**Consultation Response from KC,  
Highways Development Management**

**2023/90845 4, Westgate, Heckmondwike, WF16 0EH**

**Change of use to vehicle sales unit**

**Date Responded: 14-8-2023.**

drawing SITE LAYOUT PLAN

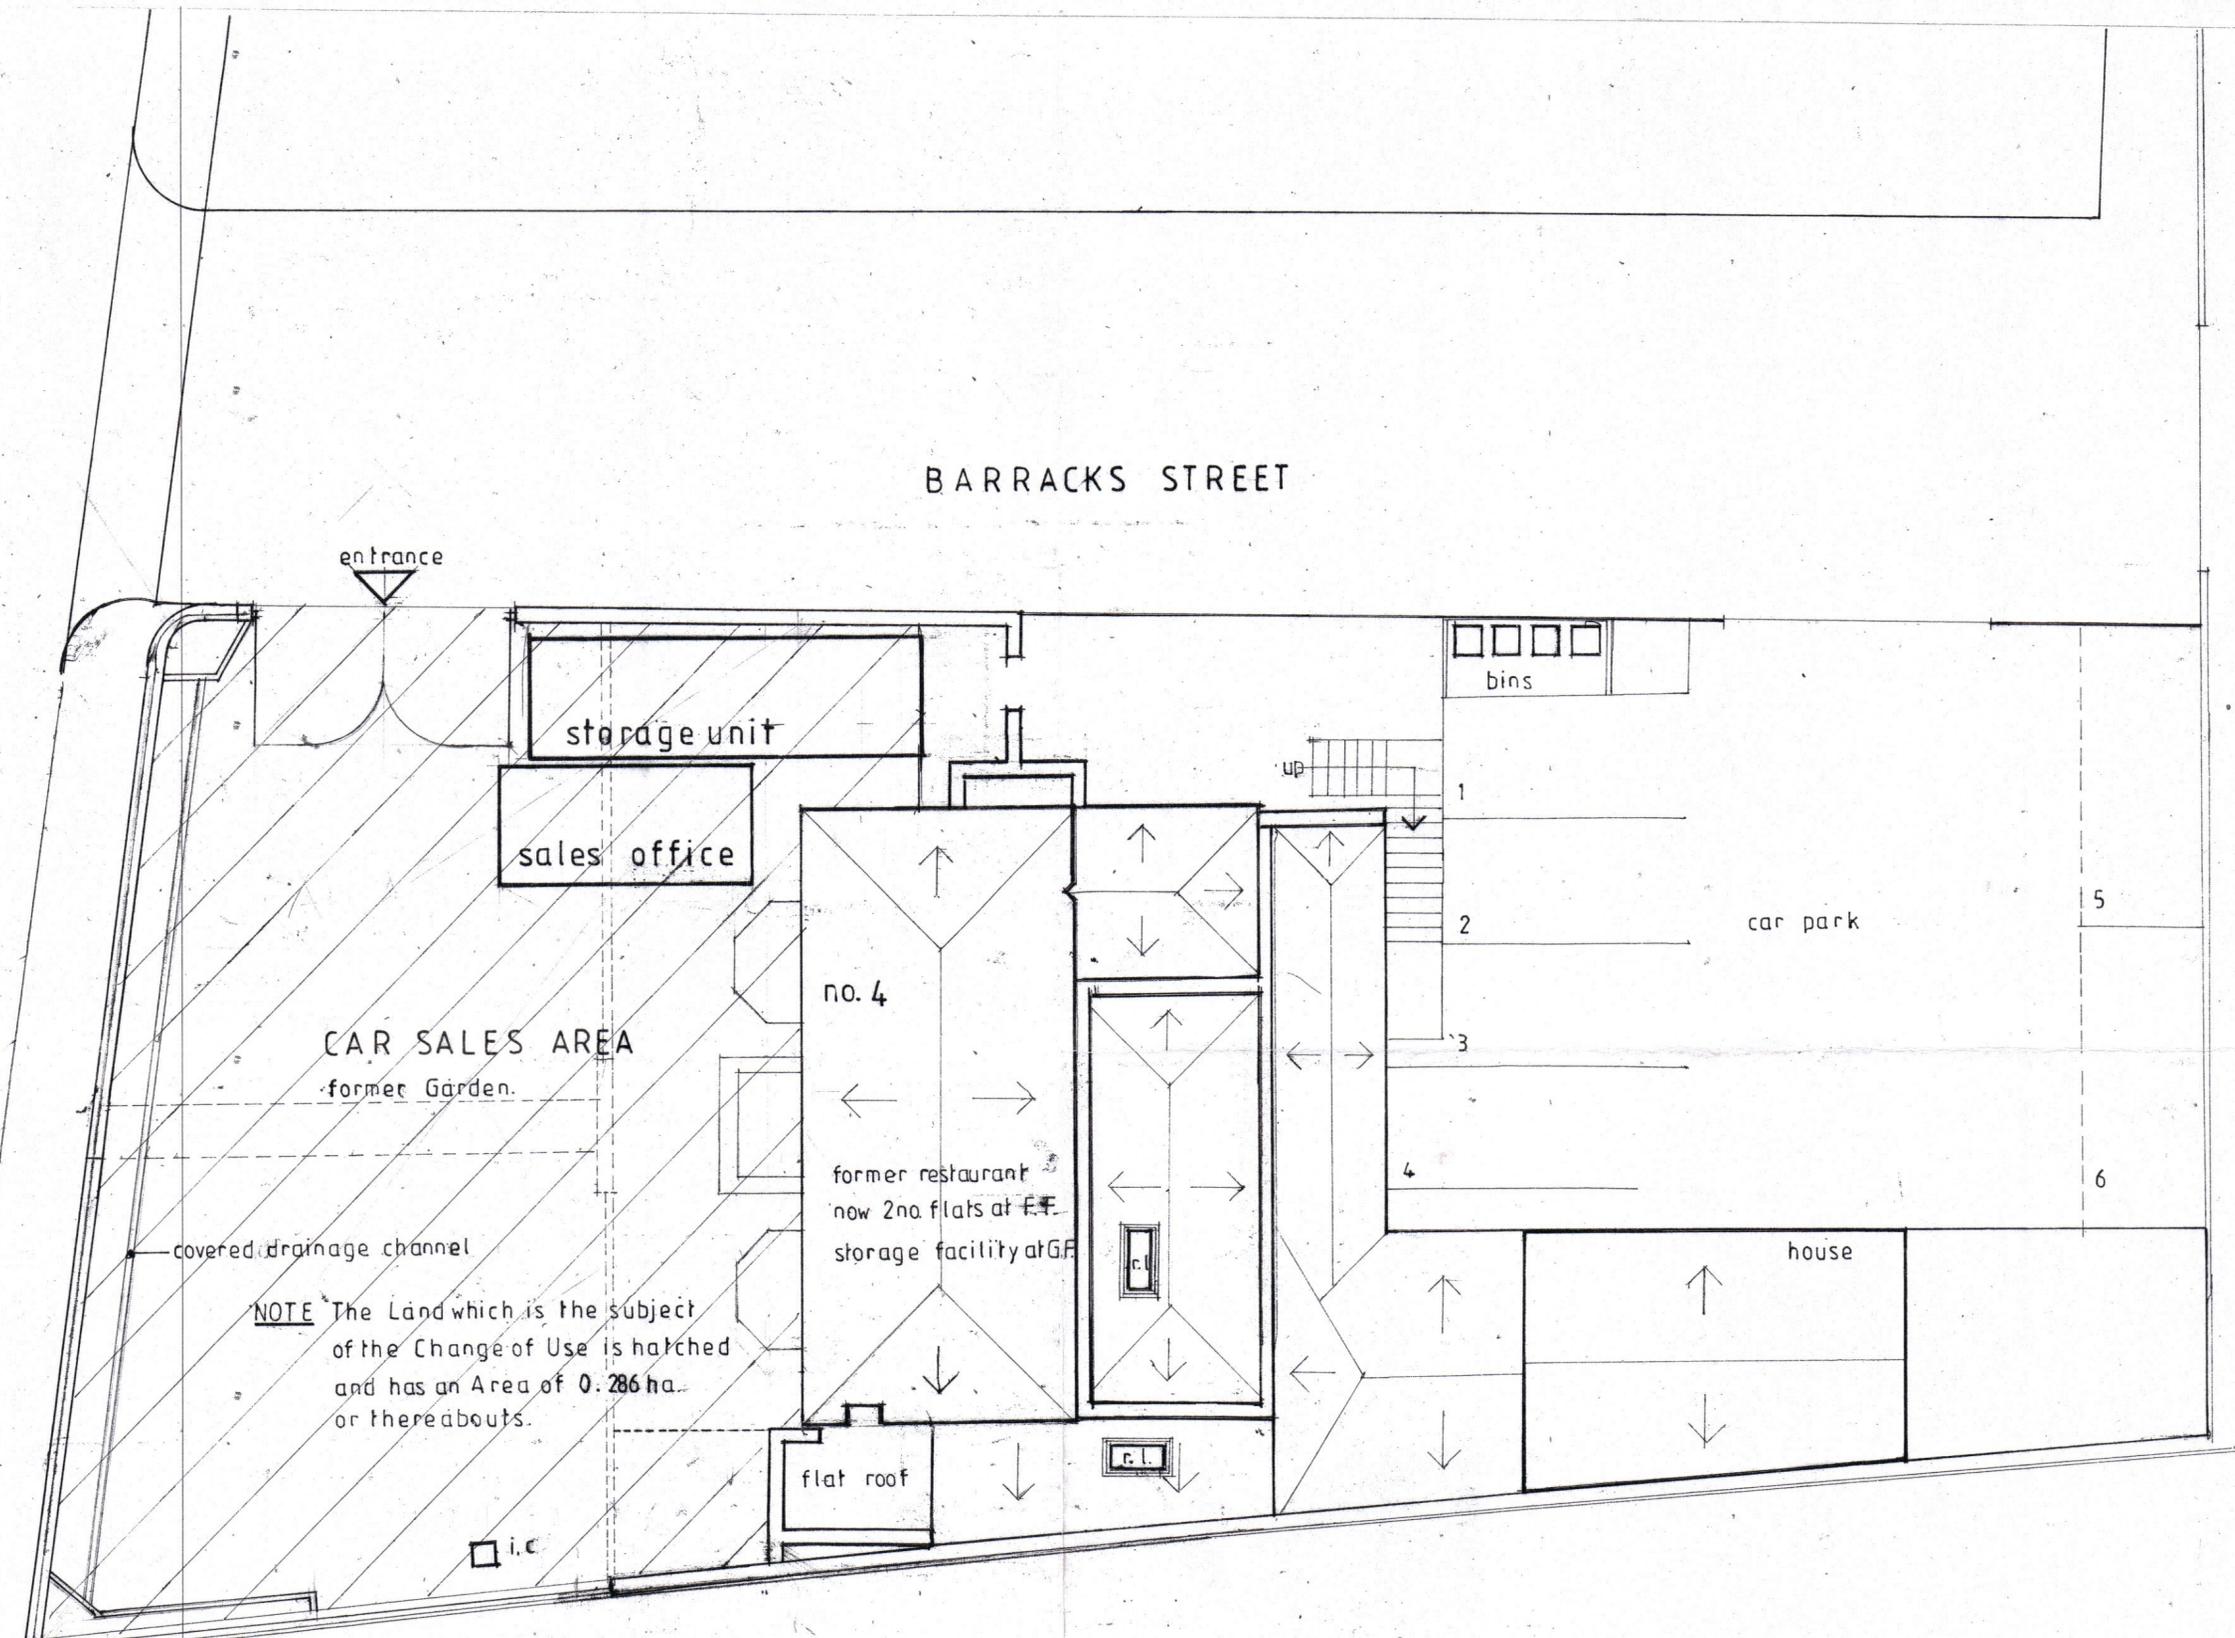
Given the small scale of these proposals Highways Development Management (HDM) have no objection to these proposals in principle HDM would however recommend that the plans are amended to show one staff and one customer parking space within the site.
